KITTITAS COUNTY

DEPARTMENT OF PUBLIC WORKS

MEMORANDUM

SUBJECT: DW Farms Short Plat SP-08-21

**DW FARMS SHORT PLAT**  
LOCATED IN SECTION 32, TOWNSHIP 18 NORTH, RANGE 20 EAST, W.M.  
KITTITAS COUNTY, WASHINGTON  
SP-

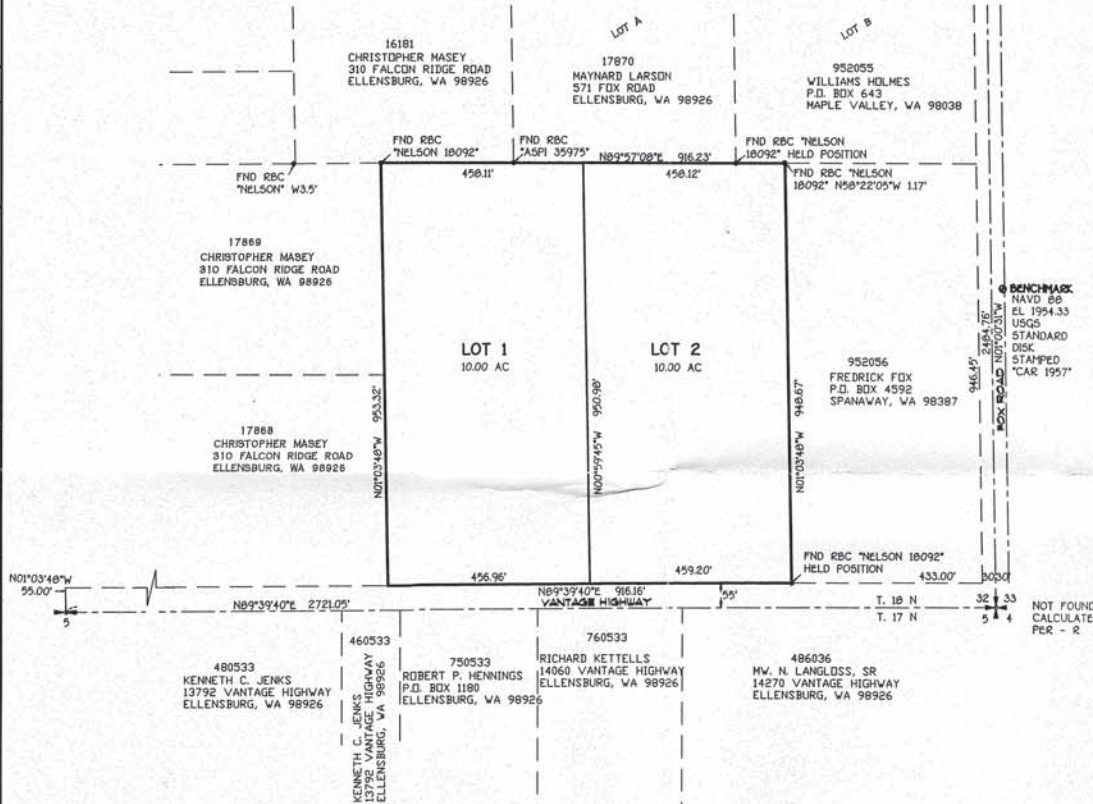
1. Legal Description: The legal description shall be corrected to read “... as recorded January 7, 2005, in Book 30 of Surveys, Page 222...”
2. Easement ‘R’: The west boundary of the property is encumbered by Easement ‘R’ as recorded in Book 28 Page 231 and deeded to neighboring properties. The easement shall be shown on the final plat.

3. Access: Vantage Highway is classified as a Rural Minor Collector and has an access spacing requirement of 300’. If access to Lot 1 is proposed from Easement ‘R’ the road will need to be improved to the requirements of a High Density Private Road that serves 3-14 lots. Access may also be from single-use or joint-use driveways. If the existing access is not used it shall be removed.

4. Existing Access: The existing access shall be shown on Sheet 1 of 2.
5. Joint-Use Driveway: A joint-use access shall serve no more than two tax parcels. See Kittitas County Road Standards, 9/6/05 edition.
